Current Zoning: MUDD-O (Mixed Use Development District, Optional)
Proposed Zoning: MUDD-O SPA (Mixed Use Development District, Optional, Site Plan Amendment)

Approximately 10.6 acres bound by the south side of Abbey Place, east side of Park Road, west side of Hedgemore Drive, and north side of Mockingbird Lane.

The petition proposes to increase the number of residential units from 450 units to 550 units.

Staff recommends approval of this petition upon resolution of outstanding issues related to transportation and urban forestry.

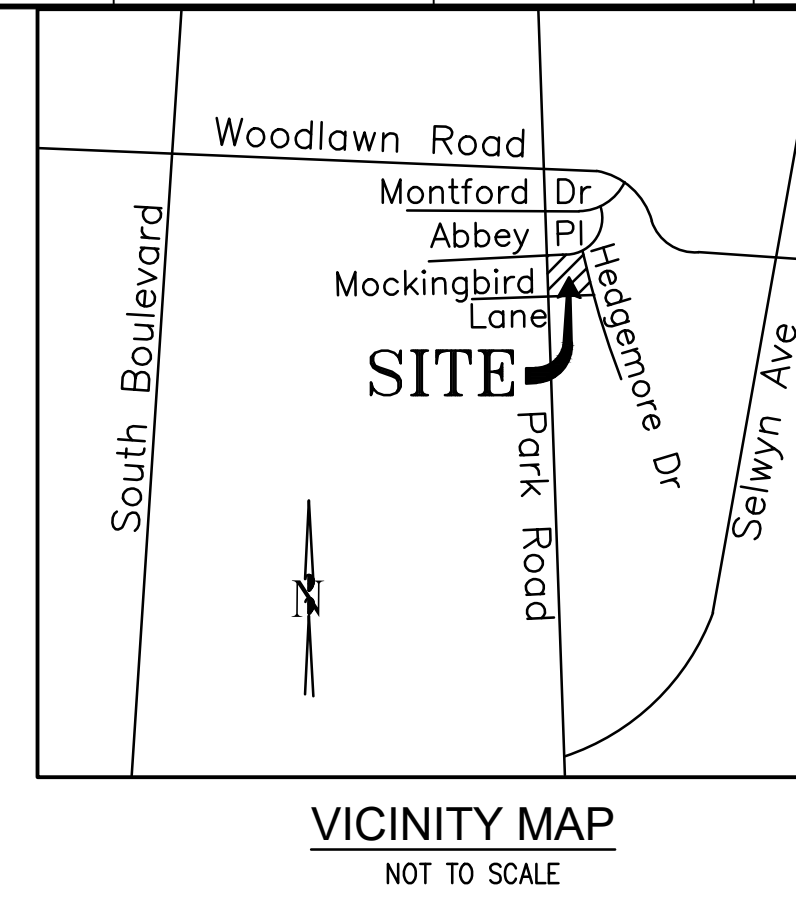
1. Site plan needs to show dimension of future back of curb from centerline.

2. Tree survey required. Missing street trees along Hedgemore Drive, Mockingbird Land, and Abbey Place.
